## 811 GLADSTONE AVENUE

Addendum No. 1

The following is an addendum to the Fotenn Planning Rationale, dated December 5<sup>th</sup>, 2018, and prepared in support of the Zoning By-law Amendment and Site Plan Control applications at 811 Gladstone Avenue. This Addendum is intended to summarize changes to the requested Zoning By-law Amendment as a result of circulation comments received from the City of Ottawa and Ward Councillor.

PROPOSED ALTERNATIVE RACKS:  
DERO DUPLEX STACKED BIKE RACKS:  
TOTAL INTERIOR YIELD  
120

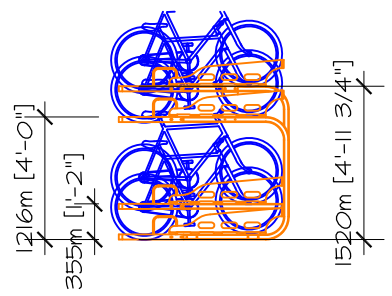
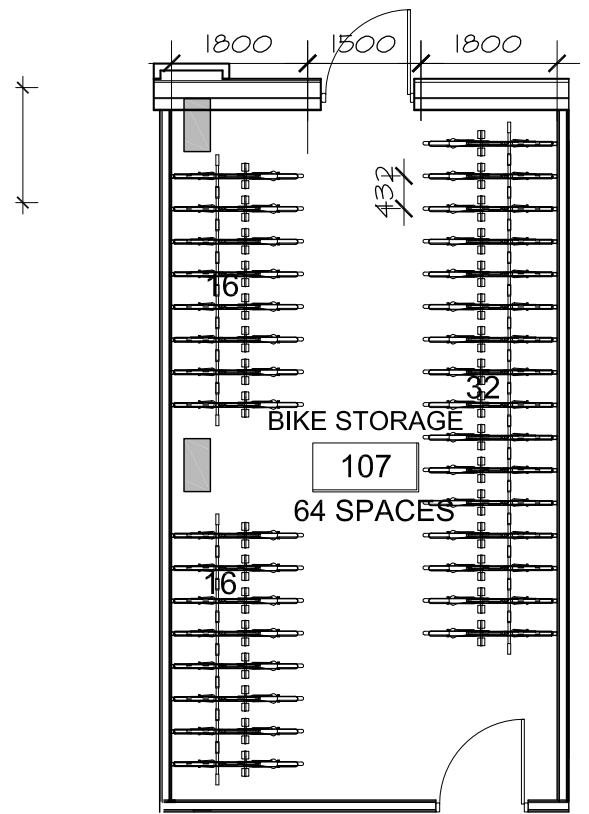
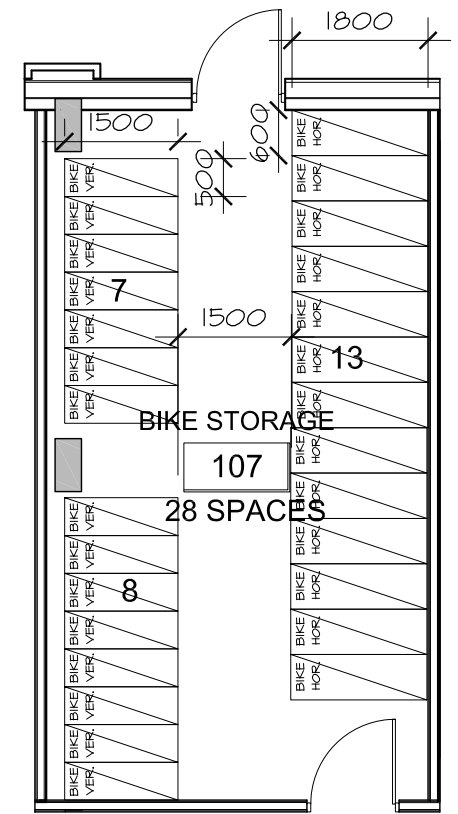
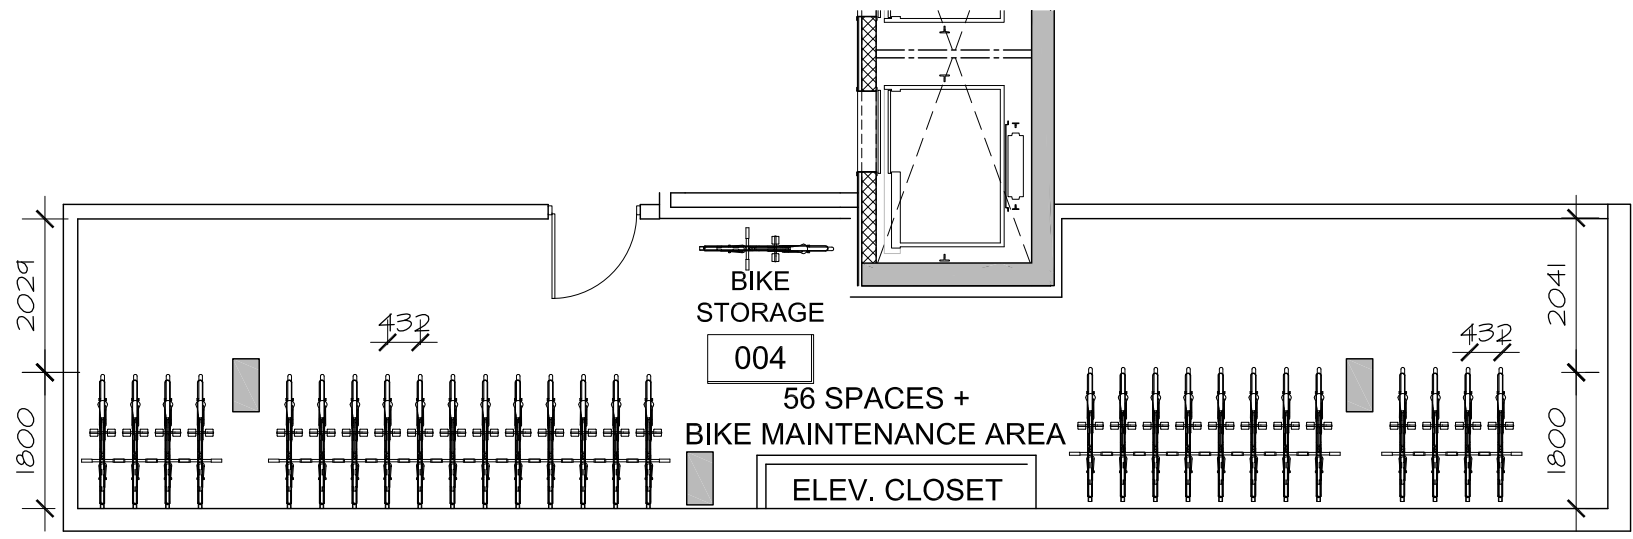
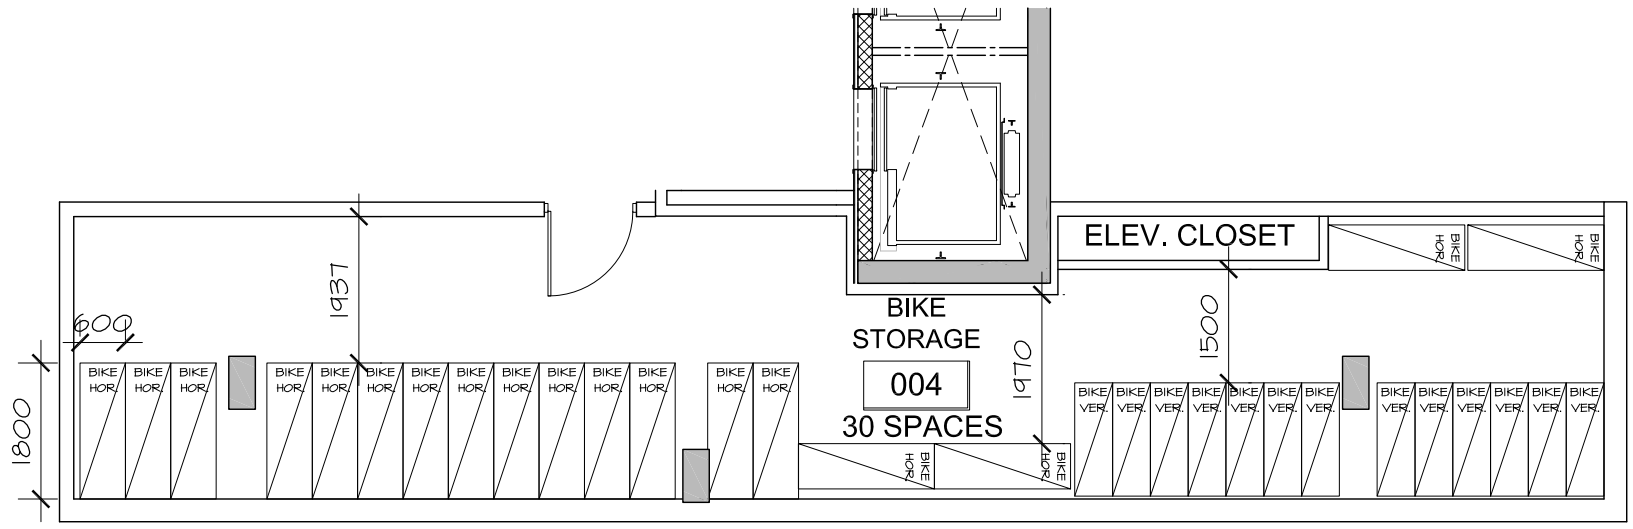
The proposal also includes alternative bicycle rack design which will increase the total provided spaces up from 86 to 120 racks. The proposed design as included in this resubmission provides for ground level as well as stacked bicycle parking options and would require a reduction in the required width of the bicycle parking space of 0.432 metres whereas the Zoning By-law requires a minimum width of 0.6 metres.

It is our opinion that the proposed stacked bicycle parking space design will facilitate the provision of 36 additional spaces while ensuring a similar standard of use for those tenants utilizing these racks.

Importantly, the required number of bicycle parking spaces will be achieved through the ground level portion of the stacked rack design with the remaining spaces representing surplus spaces, above and beyond the Zoning By-law requirement.
